Your Ref: OWPC20554
Our Ref: WA/90/18/HH 15-10-2018
Please ask for:
Mrs C Easton

13th November 2018

Retrospective application for rear single storey extension.
Chillerton Down Yapton Lane Walberton

sheet 3 of 3

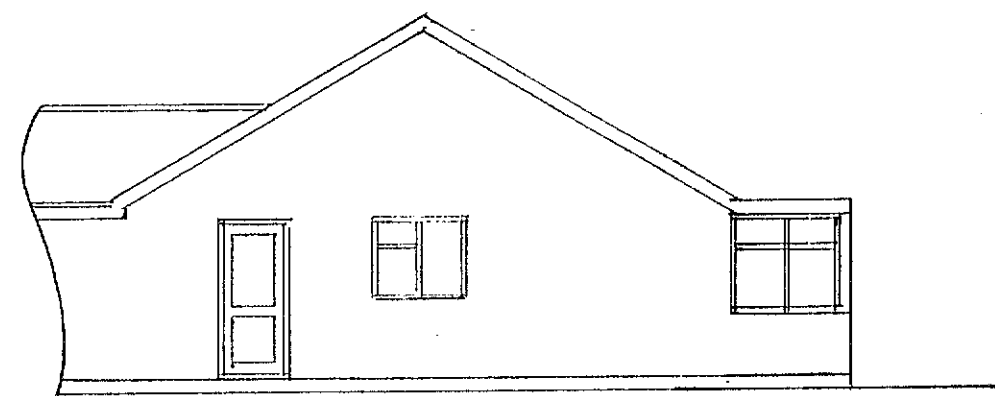
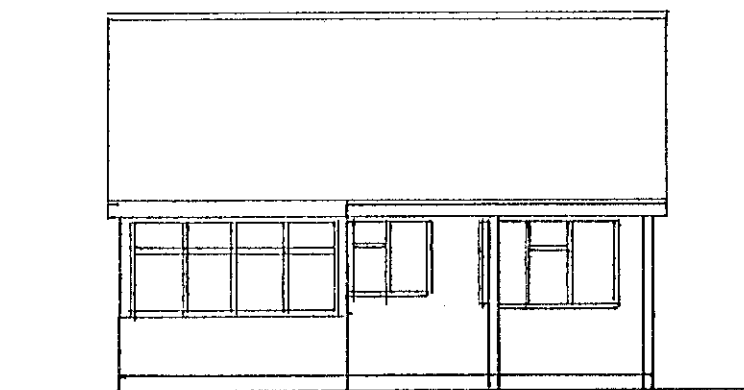
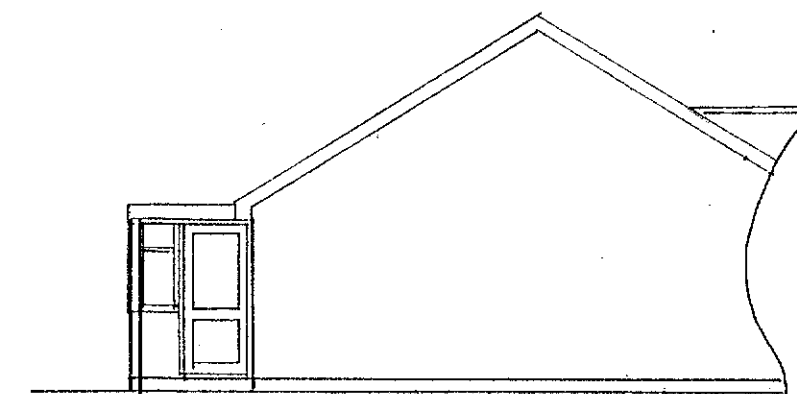
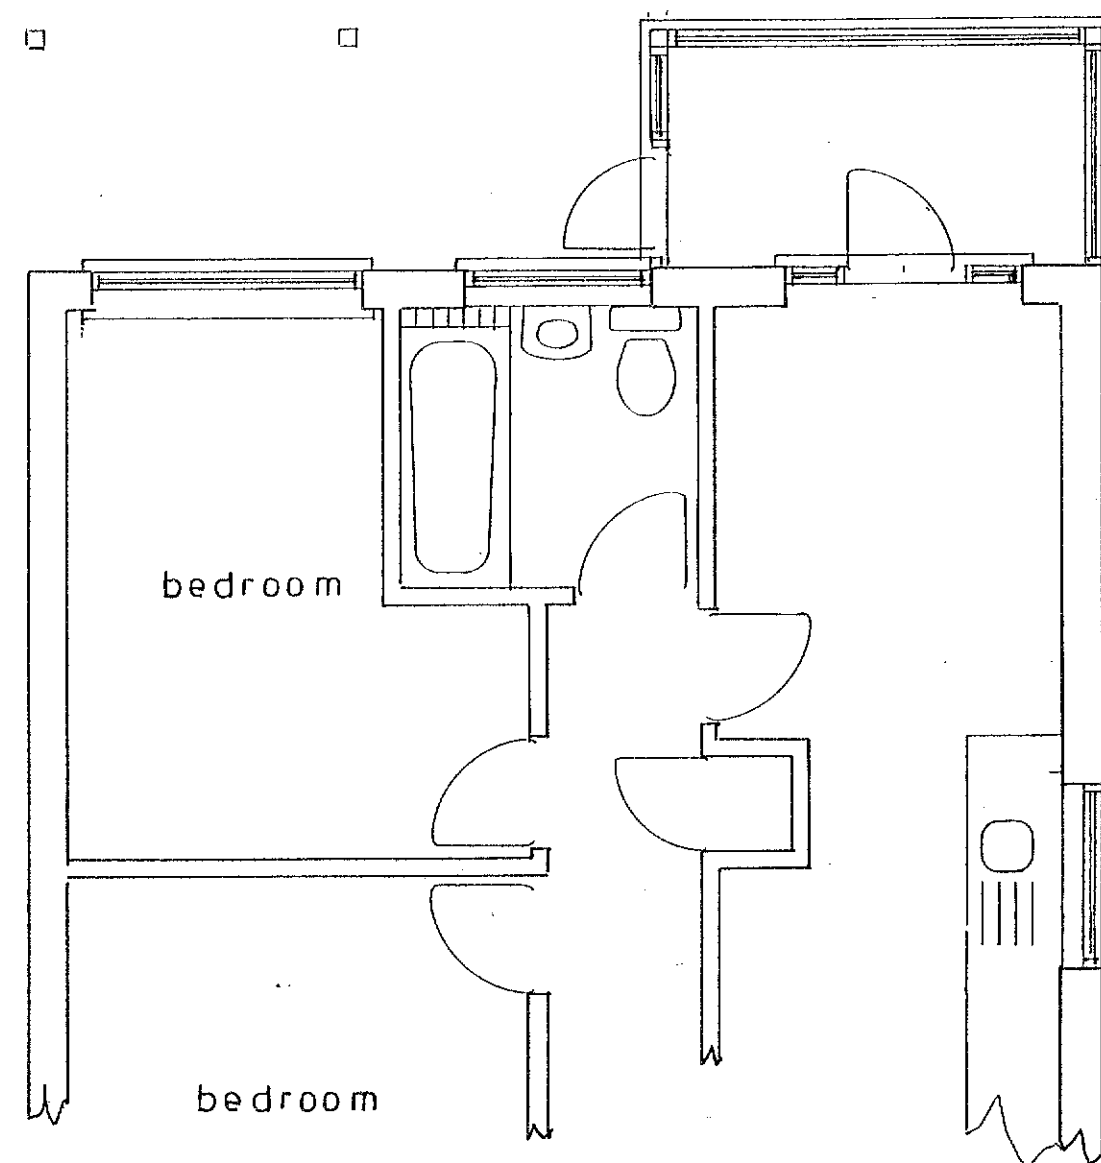
After viewing the latest drawings for retrospective planning, I feel the extension is still very intrusive on our shared drive, leaving only access for one vehicle at one time for either garage. Also I feel the drawings do not show the two soil and vent pipes that protrude even more so onto the shared drive.
